Tuck O'Brien
City Planning Director, Planning Division

September 26, 2017

Project Name:	Liberty Bay Recovery Center	Project ID:	2017-086
Address:	343 Forest Avenue	CBL:	112-D004
Applicant:	Nathan Cermelj		
Planner:	Matthew Grooms

On September 25, 2017, the Planning Authority approved a Level II Site Plan application for site work to include reconfiguration and improvement of leased parking spaces on City property and the development of a patio area to the rear of the existing building at 343 Forest Avenue in the B-2b zone. The decision is based upon the application, documents and plans as submitted. The proposal was reviewed for conformance with the standards of Portland's Site Plan Ordinance.

C2.2
MAP/LOT MAP 112 / BLOCK D / LOT 4

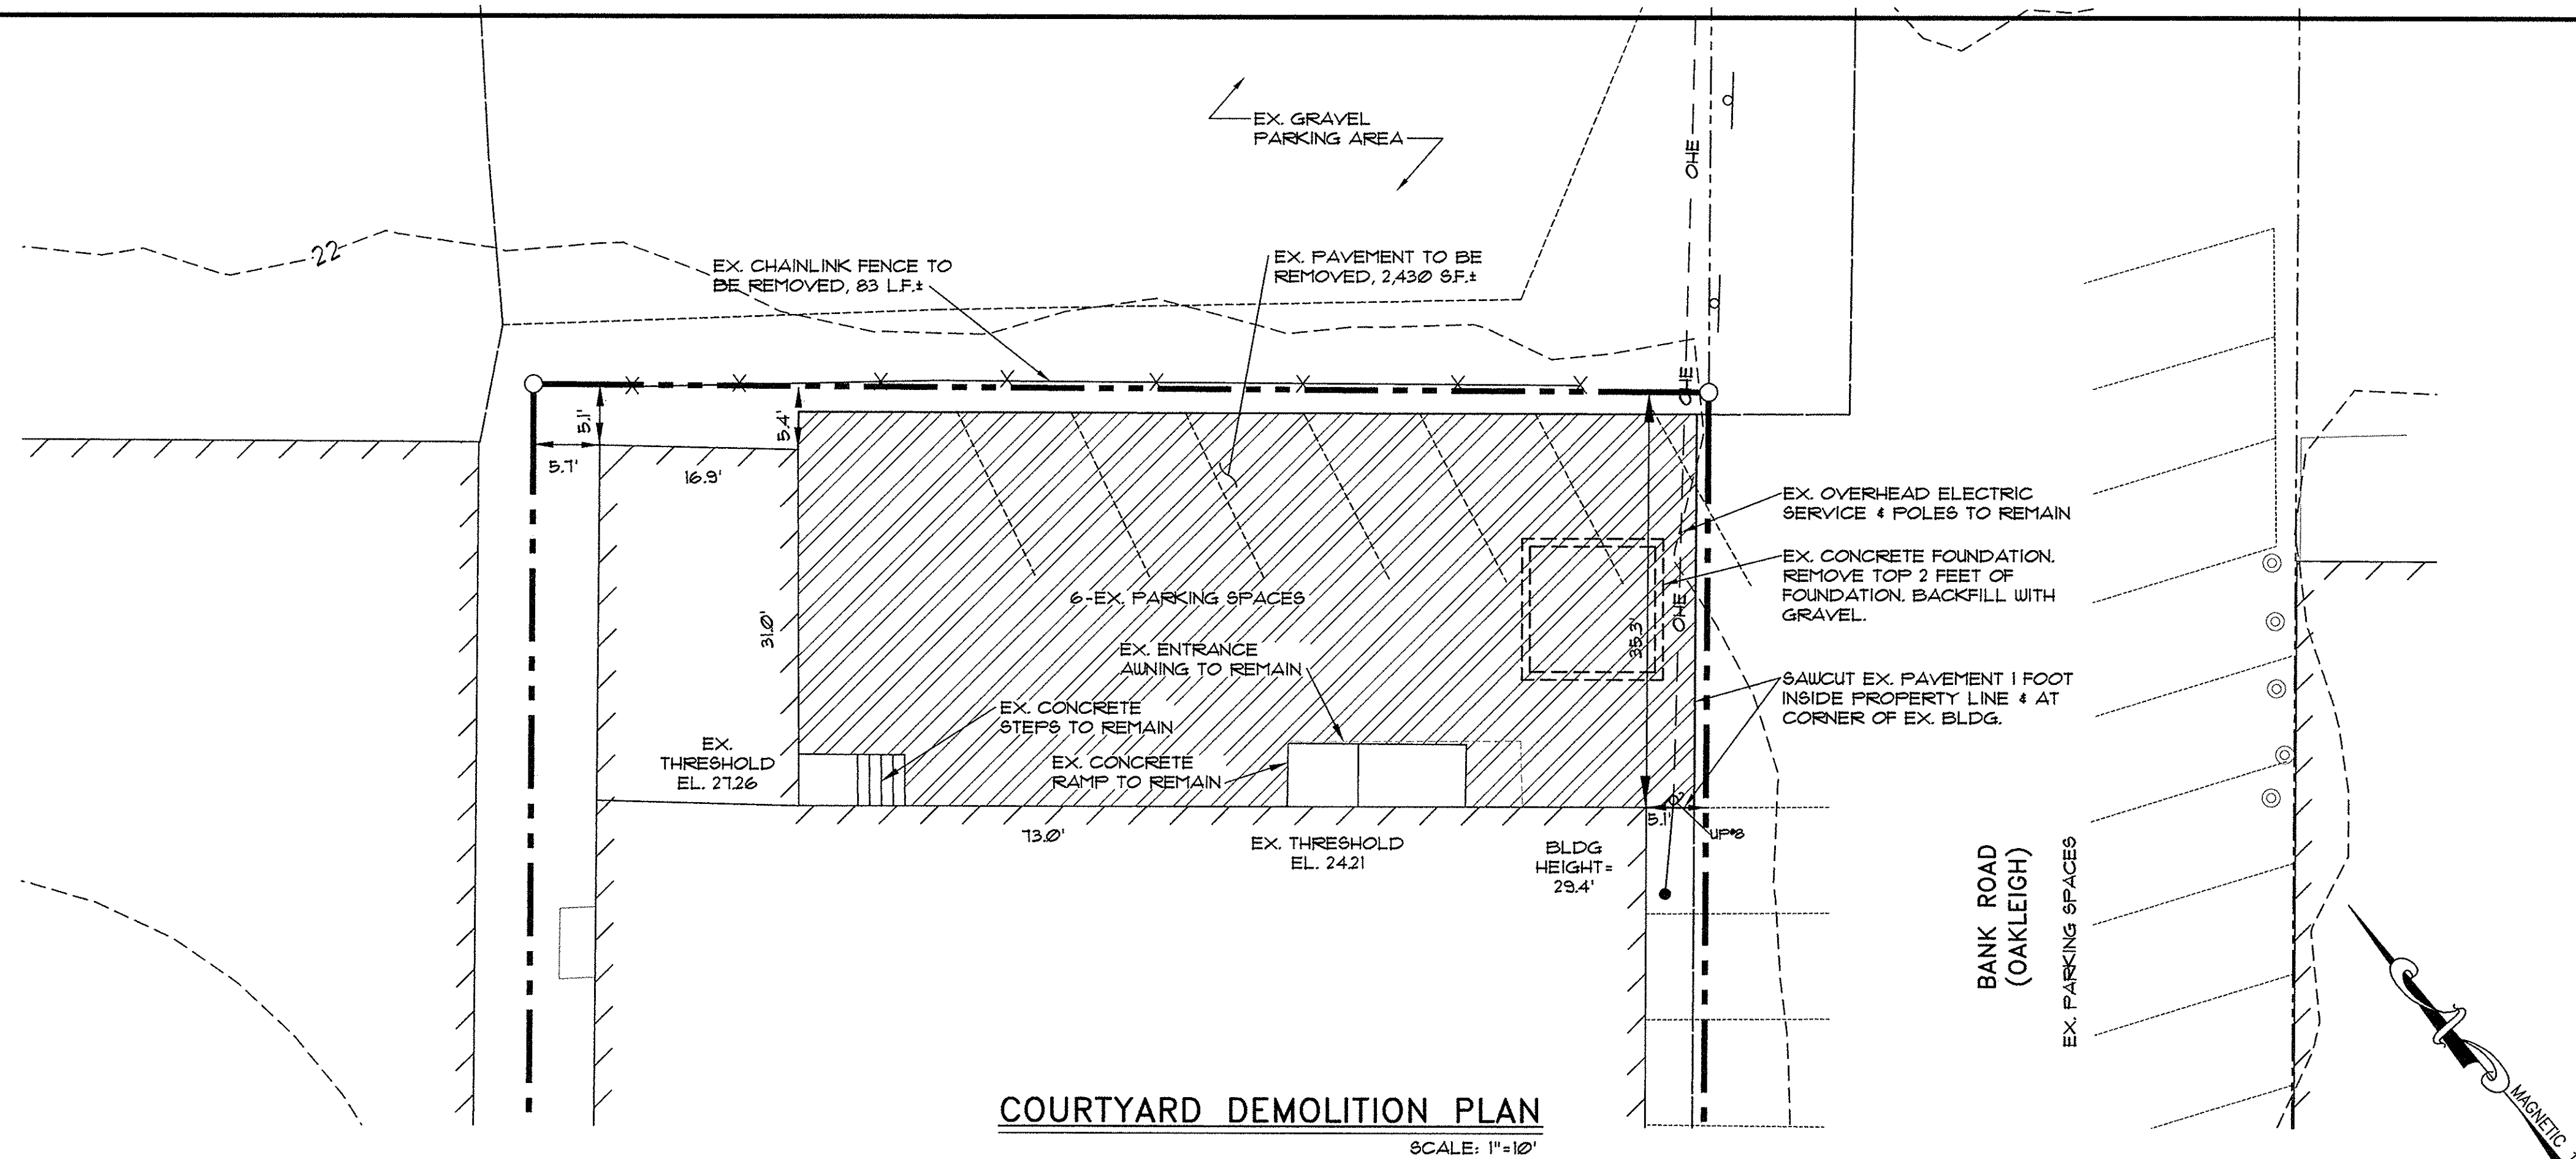
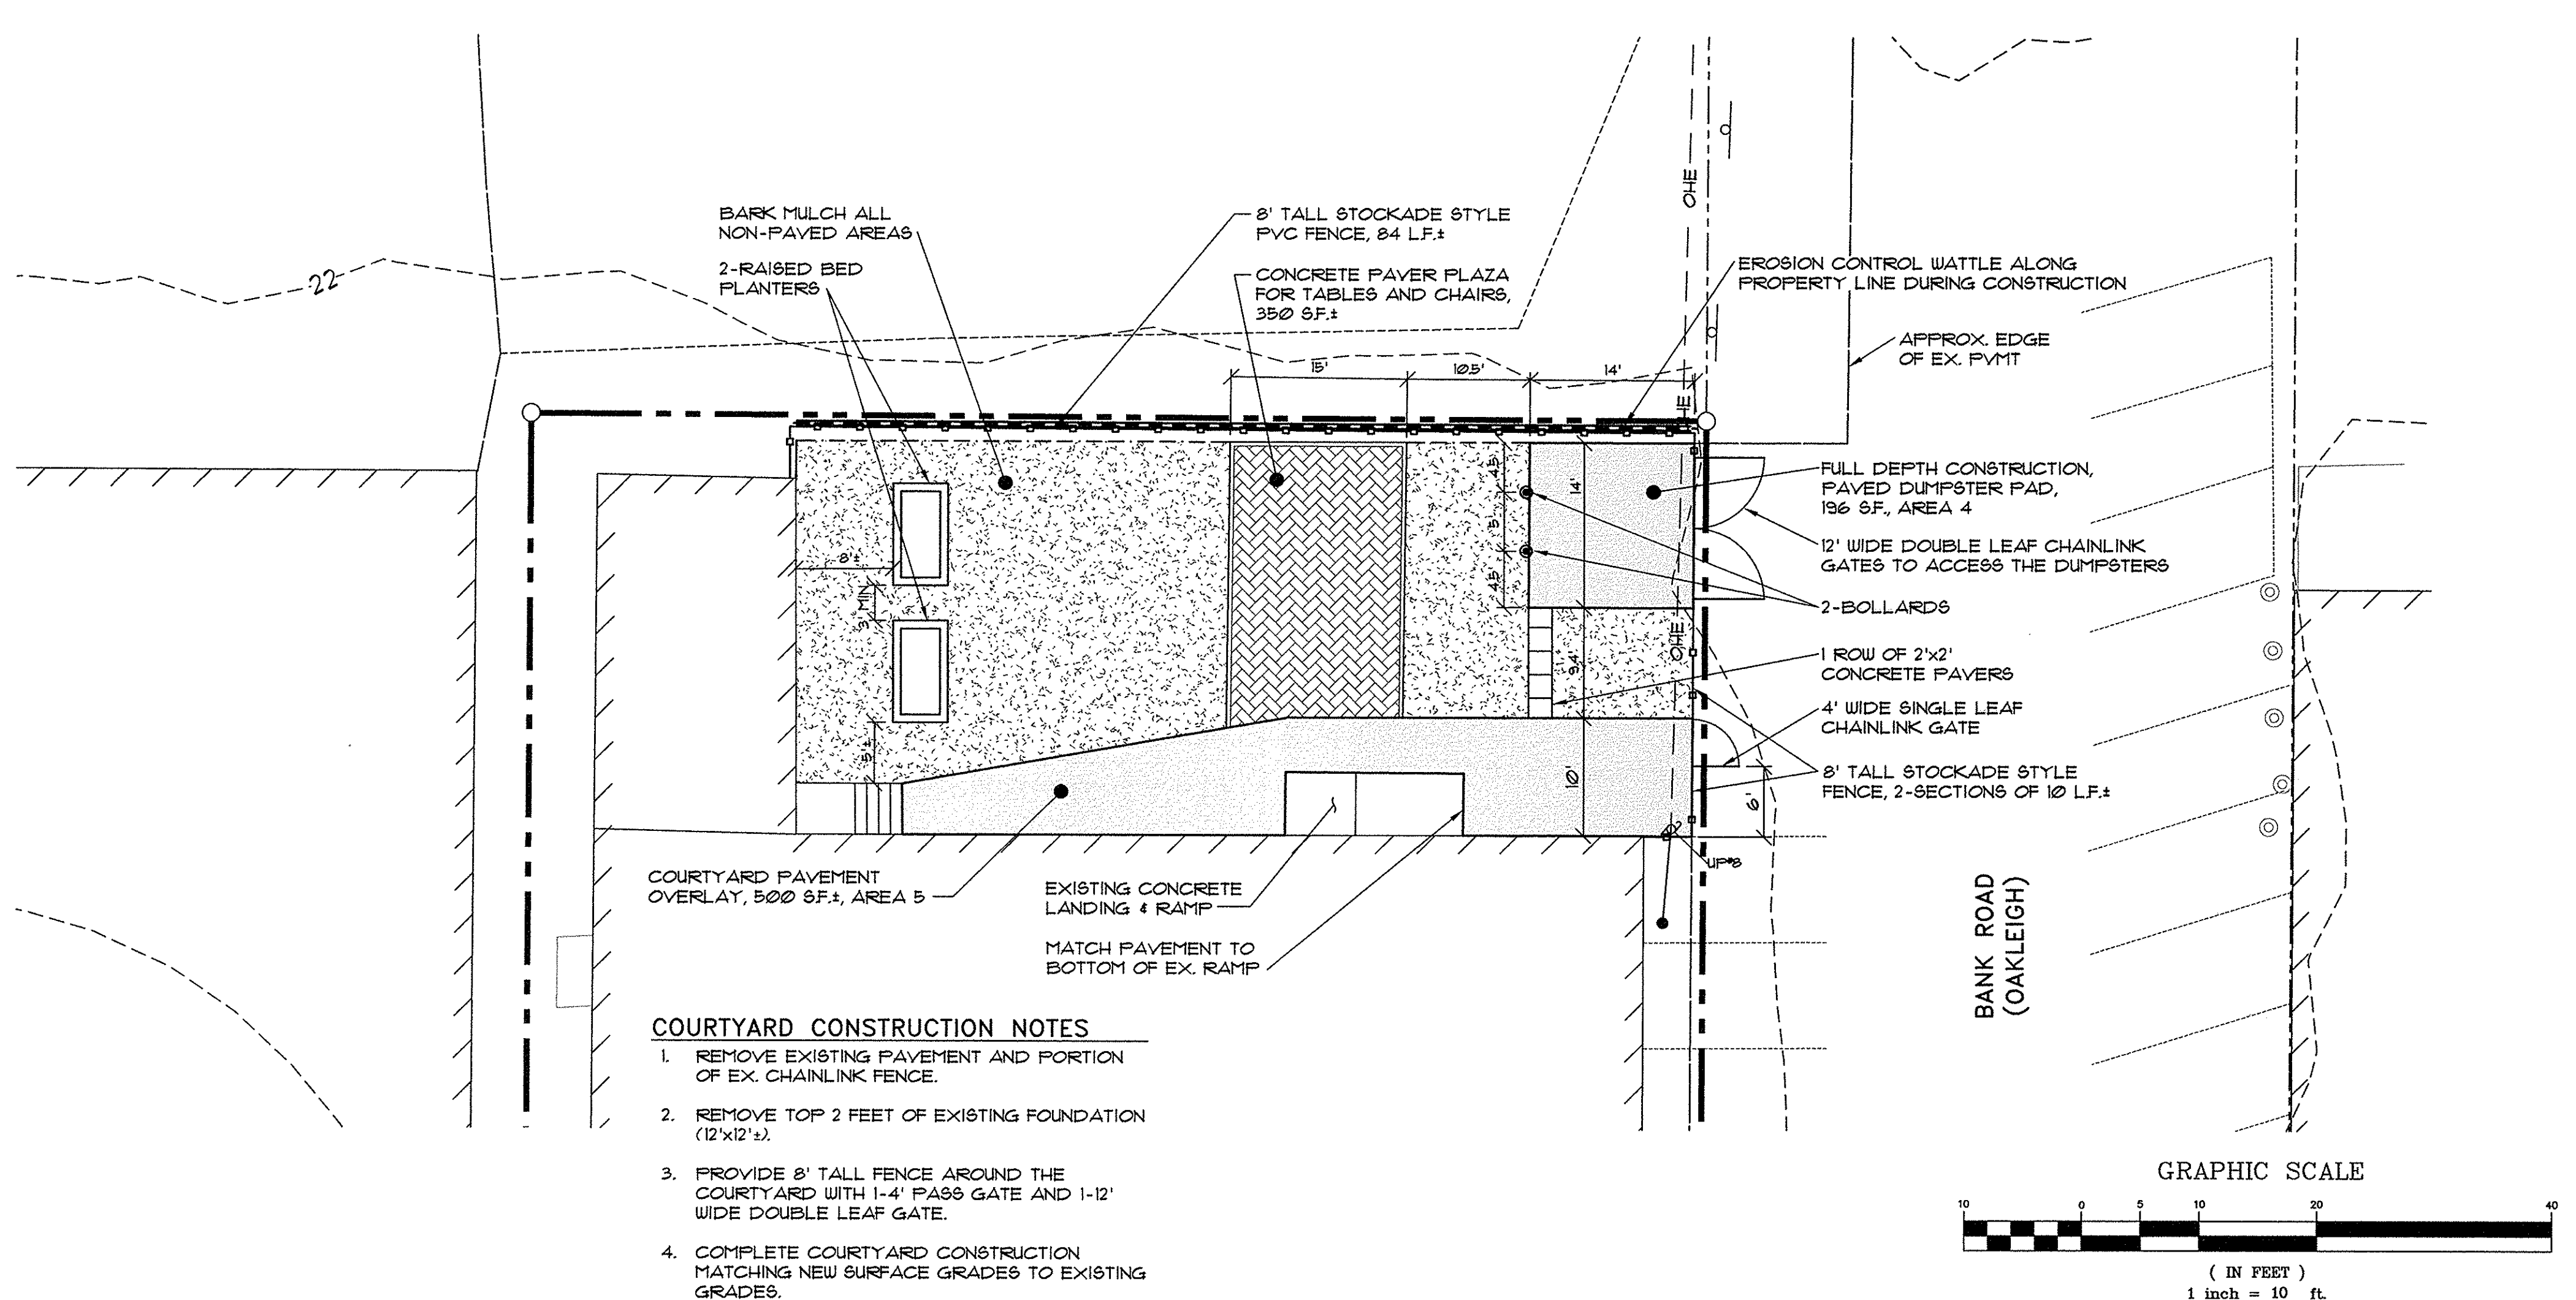
3. The two access way notes found on Sheet C2.1 reading "6' wide access way to the City of Portland from..." shall be consolidated into one note reading "Maintain a 12-foot wide vehicles and pedestrian public access centered on the lease limit line"; and
